Our ref: OR-0005246/01
Your ref: EN010153
Date: 06 July 2026

ENVIRONMENT AGENCY'S DEADLINE 4 RESPONSE

EAST PARK ENERGY

We have reviewed the [Applicant Response to Deadline 2 Submissions - Host Authorities and Statutory Environmental Bodies](#) submitted at Deadline 3 for East Park Energy.

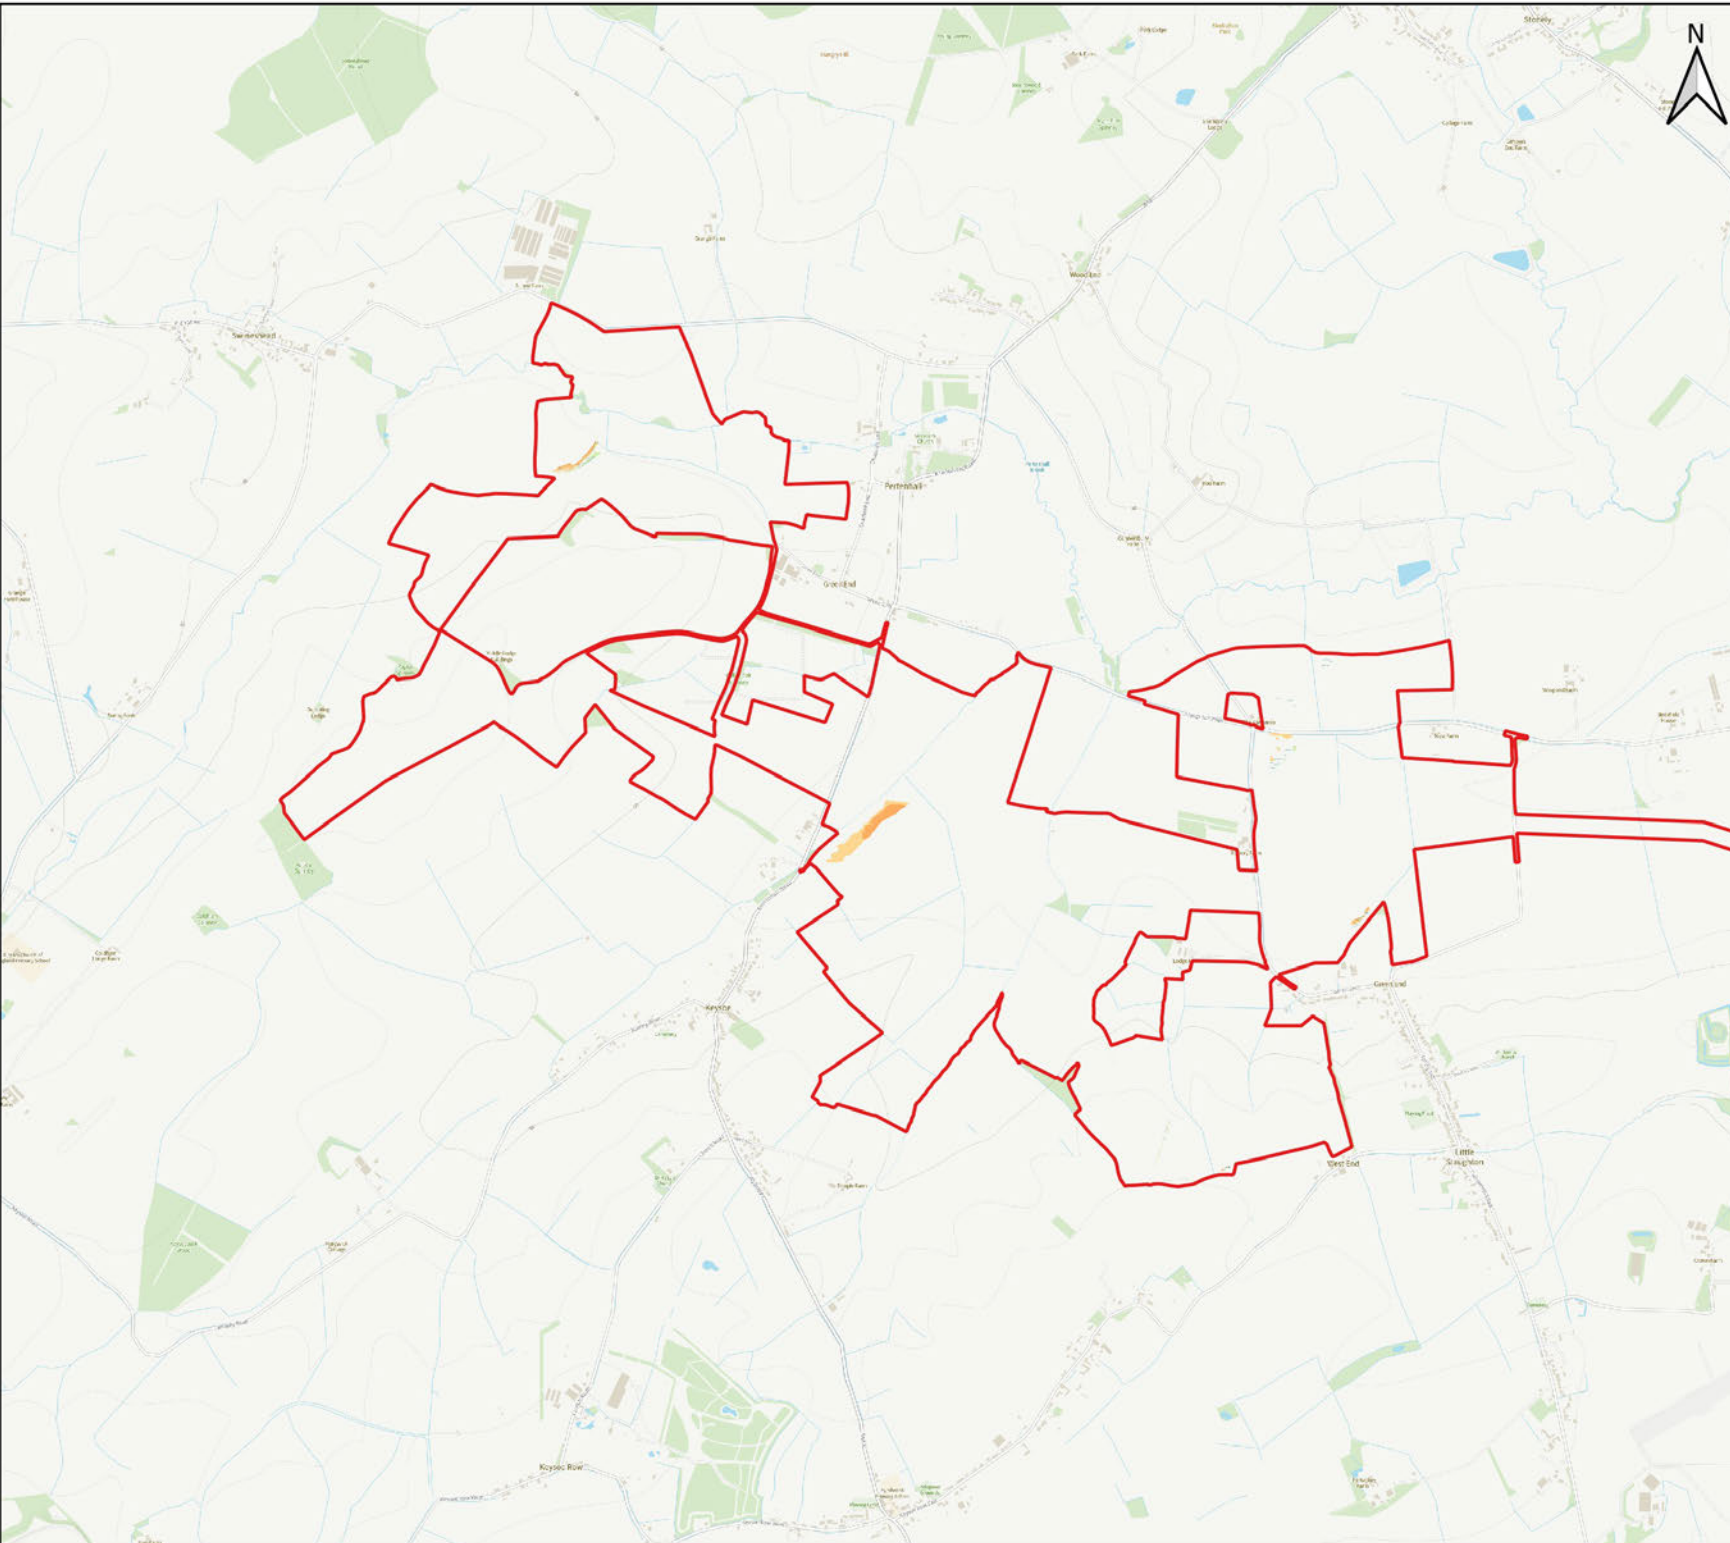
We requested that the Applicant includes details within the Flood Risk Assessment of Chapter 8 Hydrology and Flood Risk regarding the volume of storage lost from solar panel support frames and the effect on flood risk elsewhere.

The applicant has updated the Flood Risk Assessment [[REP3-039](#)] to include post development modelling to quantify the impact of the panels on flood risk.
